Appeal Decision

Appeal Ref: APP/R5510/D/22/3304526

146 Swakeleys Road, Ickenham UB10 8BA

- The appeal is made under section 78 of the Town and Country Planning Act 1990 against a refusal to grant planning permission.
 - The appeal is made by Mr Kooner against the decision of the Council of the London Borough of Hillingdon.
 - The application Ref 76229/APP/2022/898, dated 16 March 2022, was refused by notice dated 12 May 2022.
 - The development proposed was originally described as 'construction of in and out driveway'.
-

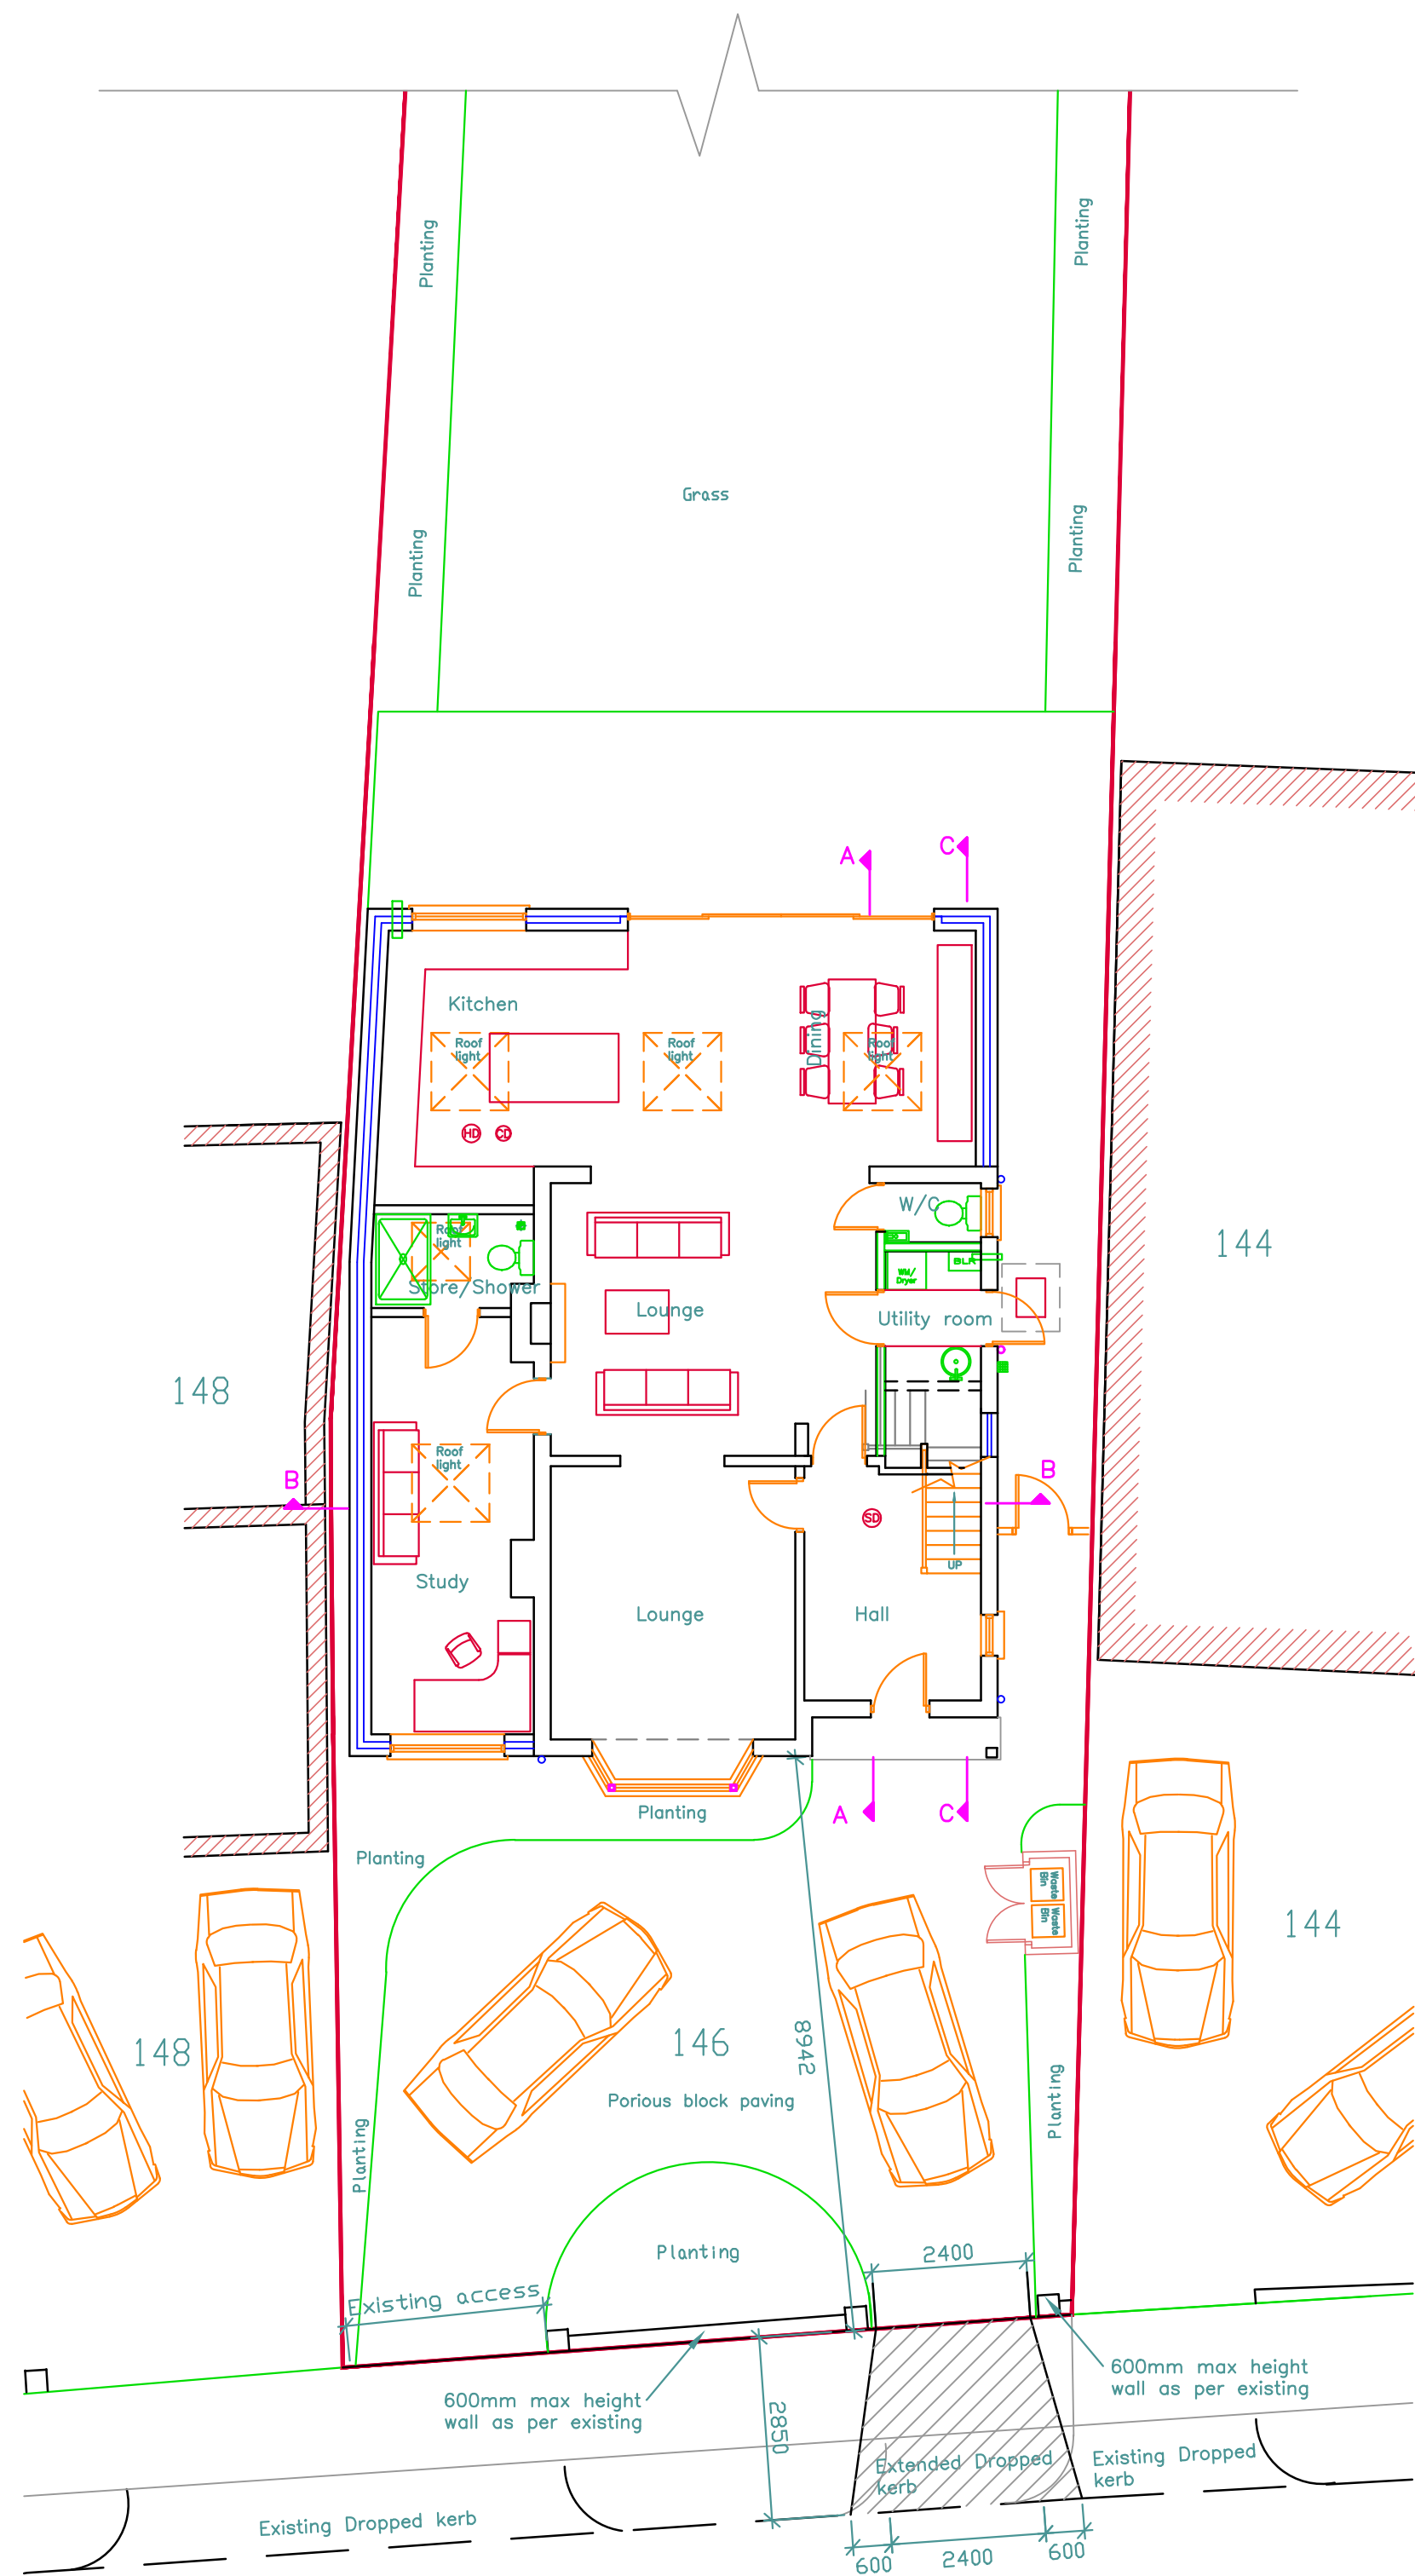
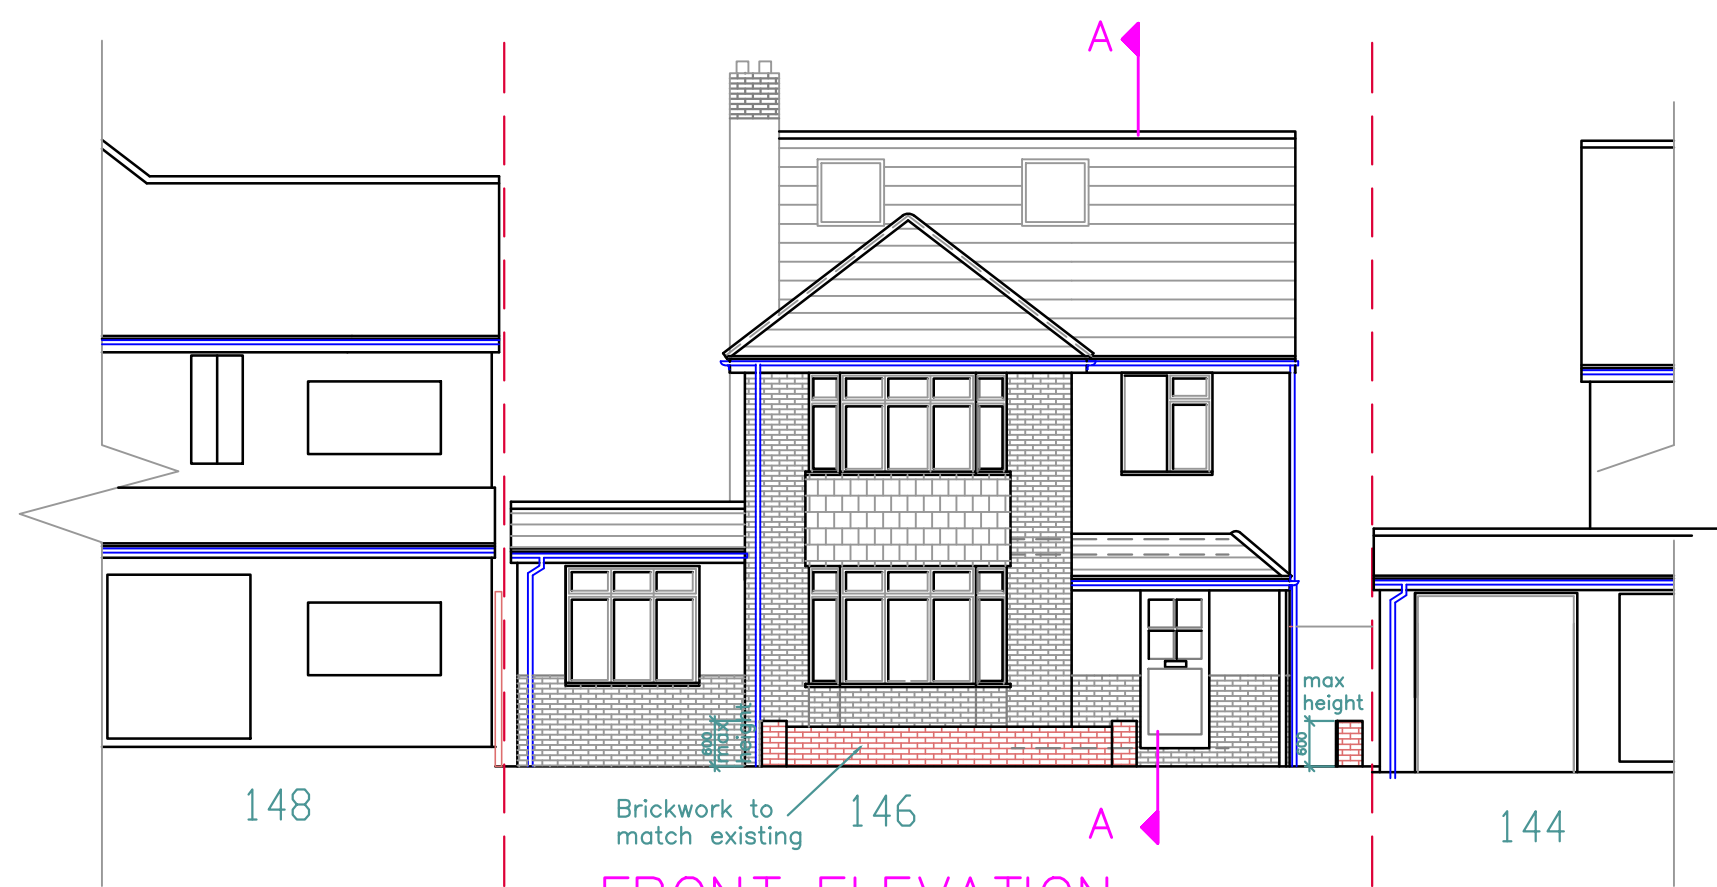
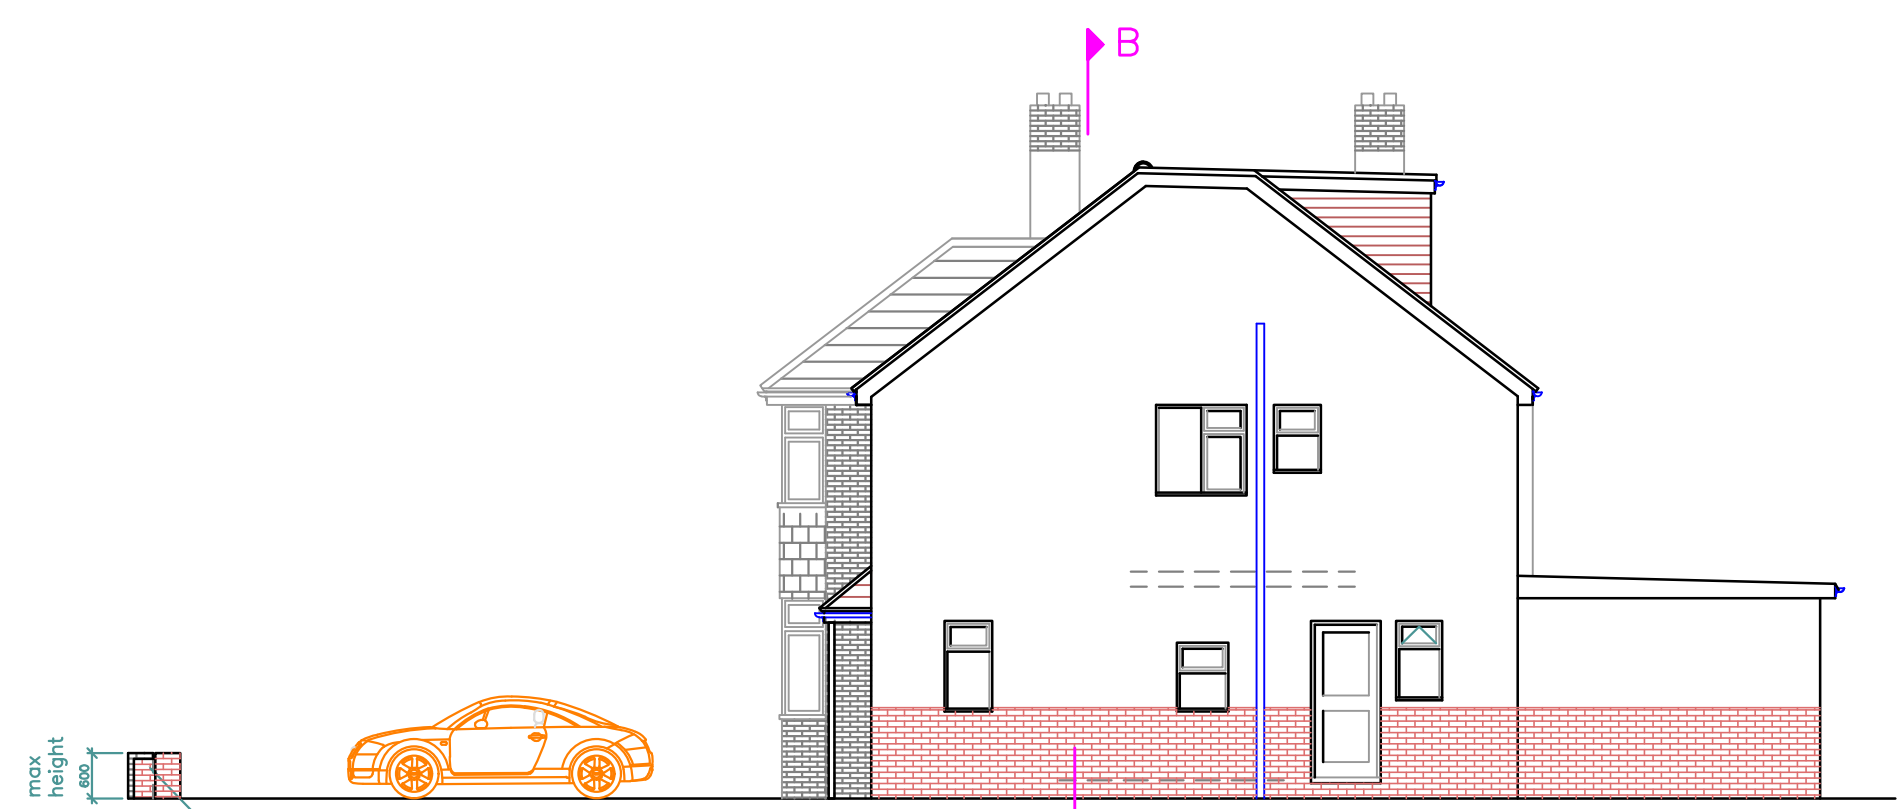
4. The appeal site includes a detached dwelling with hardstanding used for parking to its frontage. There is an existing vehicular access to the site close to the boundary with 148 Swakeleys Road which is served by a dropped kerb that also serves this neighbour. The appeal proposes a second vehicular access close to the boundary with 144 Swakeleys Road. This would be served by an extension of the existing dropped kerb that provides access to No 144.

5. There is no dispute between the main parties that the appeal site is less than 12m wide at the highway. The shortfall would be small, but the proposal would not therefore accord with the requirement within the Domestic Vehicle Footway Crossover Policy 2019 ('DVFC') for the property frontage abutting the highway to be at least 12m wide for a second crossover to be permitted.

6. Based on my observations at my visit however, turning vehicles within the site would be likely to be difficult given the dimensions of the site frontage, and would require multiple manoeuvres at the very least. This would not be convenient, and is likely to result in vehicles reversing either into or out of the site. As it passes the site, Swakeleys Road is a dual carriageway and Classified Road. At the time of my visit, I noted a fairly steady flow of traffic, and my impression was that most vehicles were travelling at or around the 30mph speed limit, if not faster. I acknowledge that this is only a snapshot, but given these conditions, it seems to me that there would currently be potential for conflict between vehicles reversing to or from the site and other highway users to the detriment of safety. The appeal proposal would provide for an 'in and out' arrangement that would enable vehicles to more easily enter and exit the site in a forward gear. In my judgement, this would be likely to reduce potential for conflict with other users of the highway and pedestrians in comparison to the existing arrangement, with an overall benefit to safety.

7. The proposed crossover would adjoin that of No 144 with no separation, but the width of the combined flat section to the crossover would not exceed the standards indicated within the DVFC for two adjoining crossovers, including where a new crossover is proposed to join an existing one. In addition, the likelihood of vehicles seeking to enter or exit the appeal site and No 144 at the same time would be very small given the size of the dwellings and parking areas so that the risk of conflict would be low. There would also be separation to the existing crossover on the site providing for a pedestrian refuge between the accesses, and this part of the street is relatively straight providing for good visibility. Consequently, I find that the combined width of the crossover would not result in any meaningful increase in potential for conflict with pedestrians, cyclists or other vehicles so as to harm safety.

1. The appeal is allowed and planning permission is granted for installation of a vehicular crossover at 146 Swakeleys Road, Ickenham UB10 8BA in accordance with the terms of the application Ref 76229/APP/2022/898 dated 16 March 2022 subject to the following conditions:
 - 1) The development hereby permitted shall begin not later than 3 years from the date of this decision.
 - 2) The development hereby permitted shall be carried out in accordance with the following approved plans: 3251-SK1, 3251-2-03, 3251-2-04 and 3251-2-05.
